Ribble Valley Borough Council  
Housing & Development Control

Application no: **3/2023/0339**

Address: **Annex at Cuttock Clough House Mill Lane Waddington BB7 3JJ**

Proposal: **Proposed change of use of the annex to use as a holiday cottage, minor changes to external fenestration and conversion of garage to a lounge.**

**Drawing No:** Hol.1060.3198.01

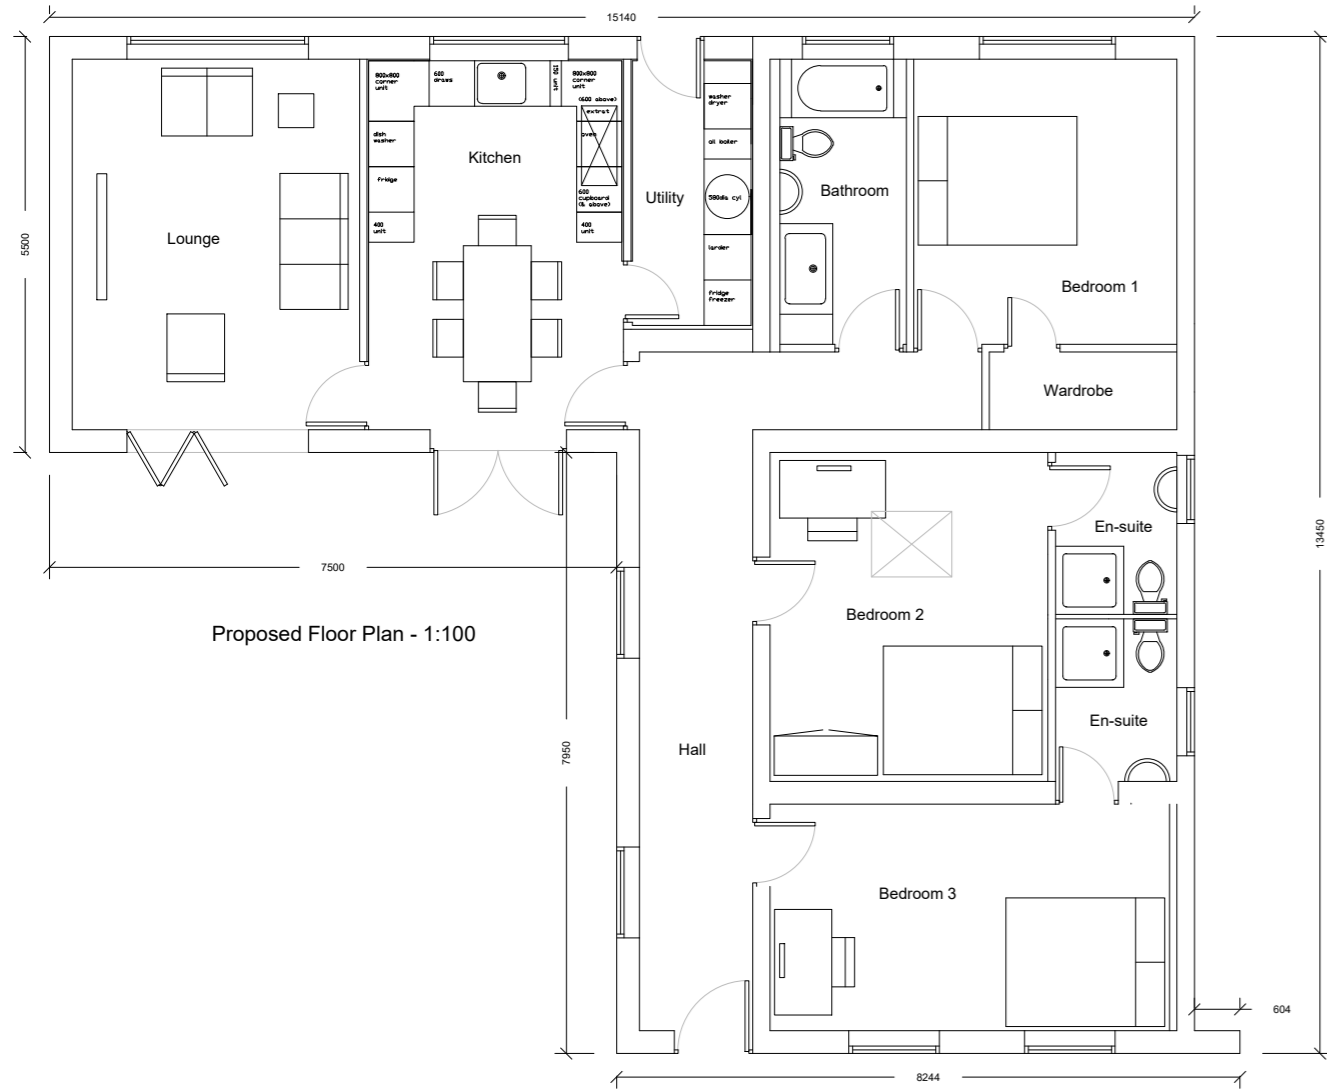
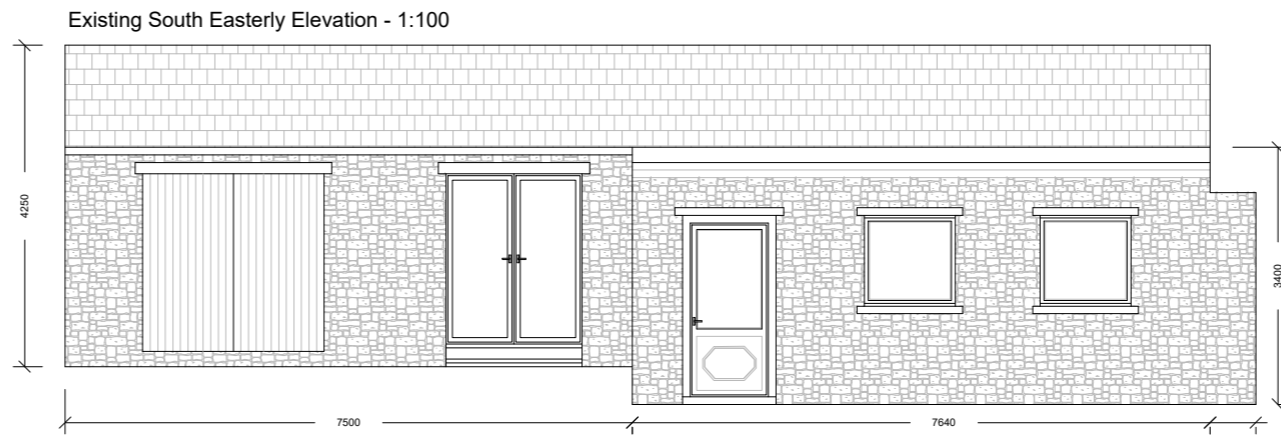
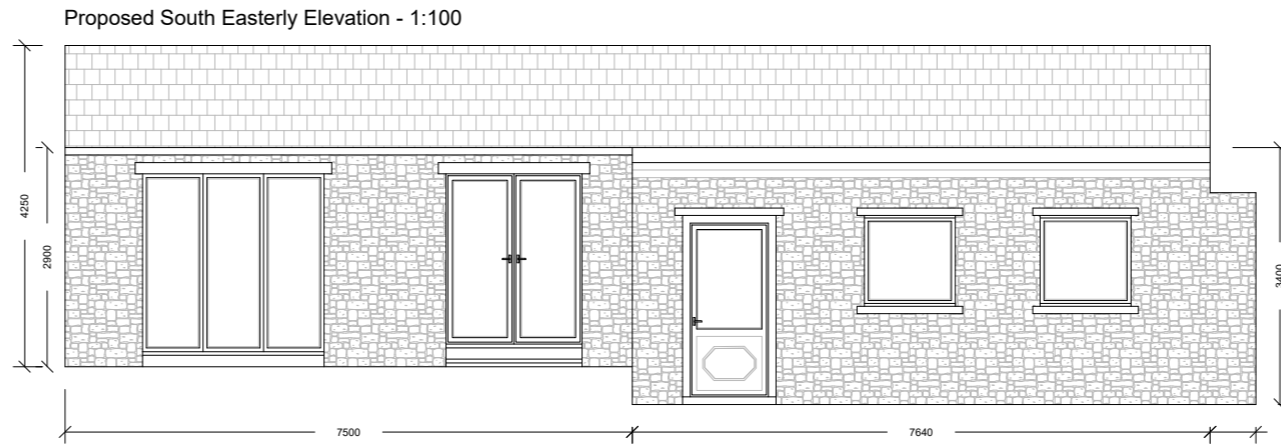
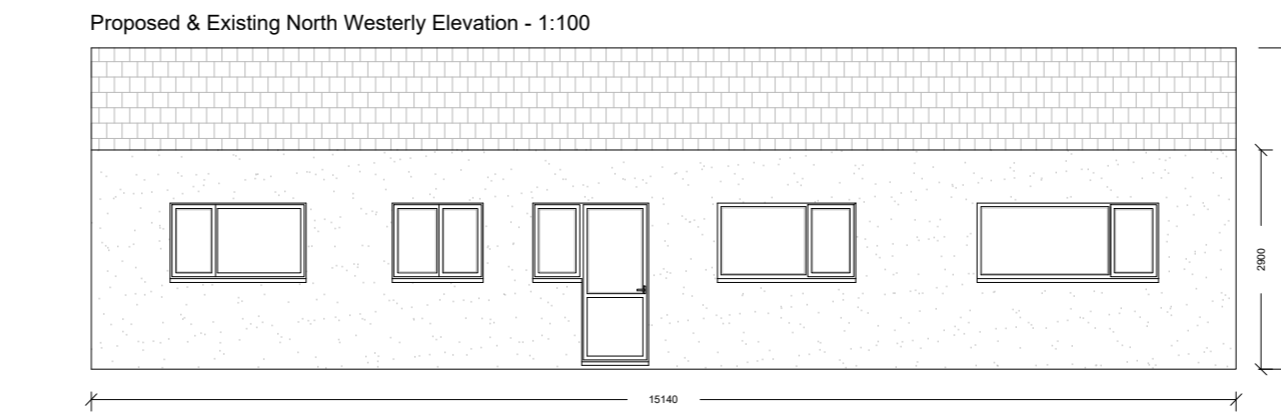
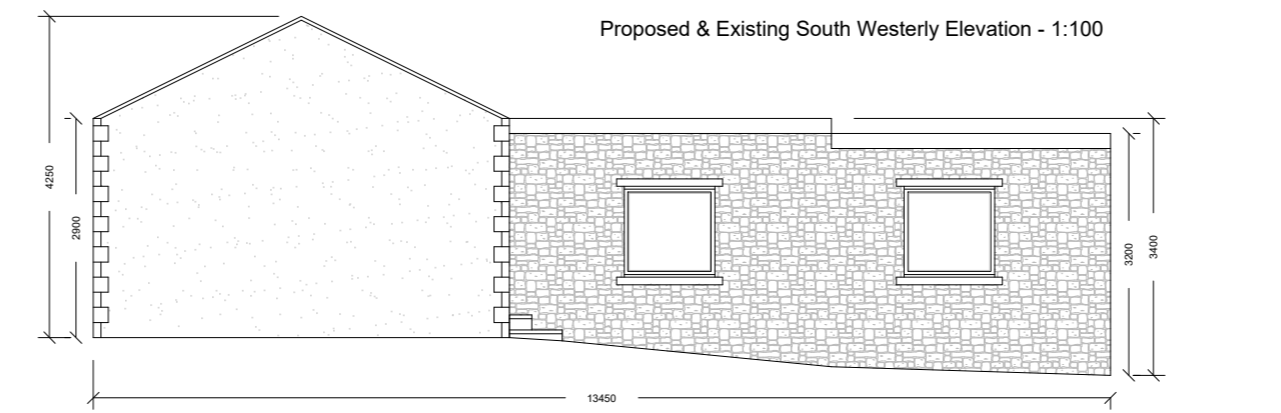
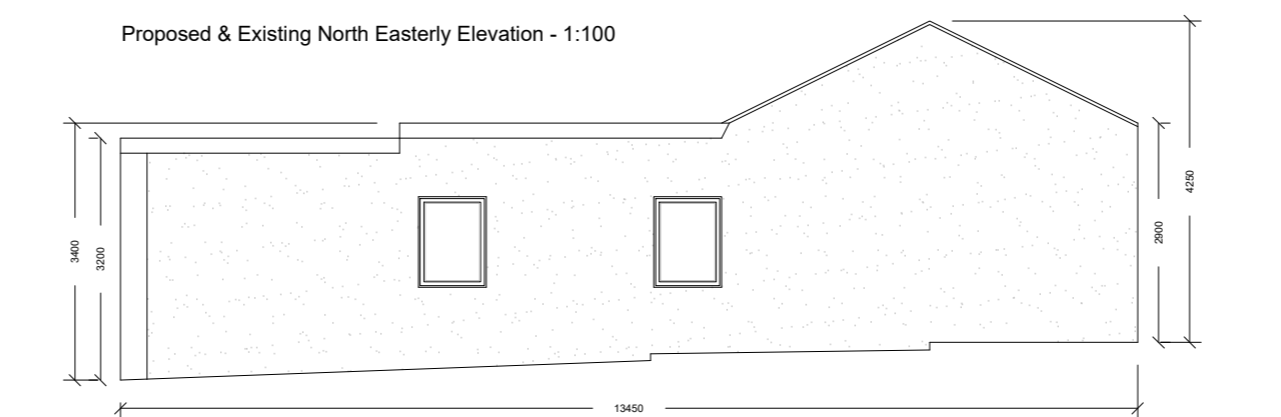
The LHA have reviewed GHA drawing number Hol.1060.3198.01 titled "Existing and Proposed Plans, Elevations, Site Plan and Location Plan" and are aware that the site complies with the LHAs parking guidance as defined in the Joint Lancashire Structure Plan for the number of bedrooms.

However, the LHA are concerned that the internal access to the proposed holiday cottage, which crosses the driveway owned by the dwelling, Cuttock Clough House, may become obstructed by parked vehicles belonging to the dwelling. Therefore, should the LHA not have objected to the application, the LHA would have requested that a parking plan was submitted for the dwelling. This would have been to ensure that the parking facilities for the dwelling would not obstruct the usability of the internal access serving the proposed holiday cottage and that the parking facilities for the dwelling would have not been compromised as a result of the application.
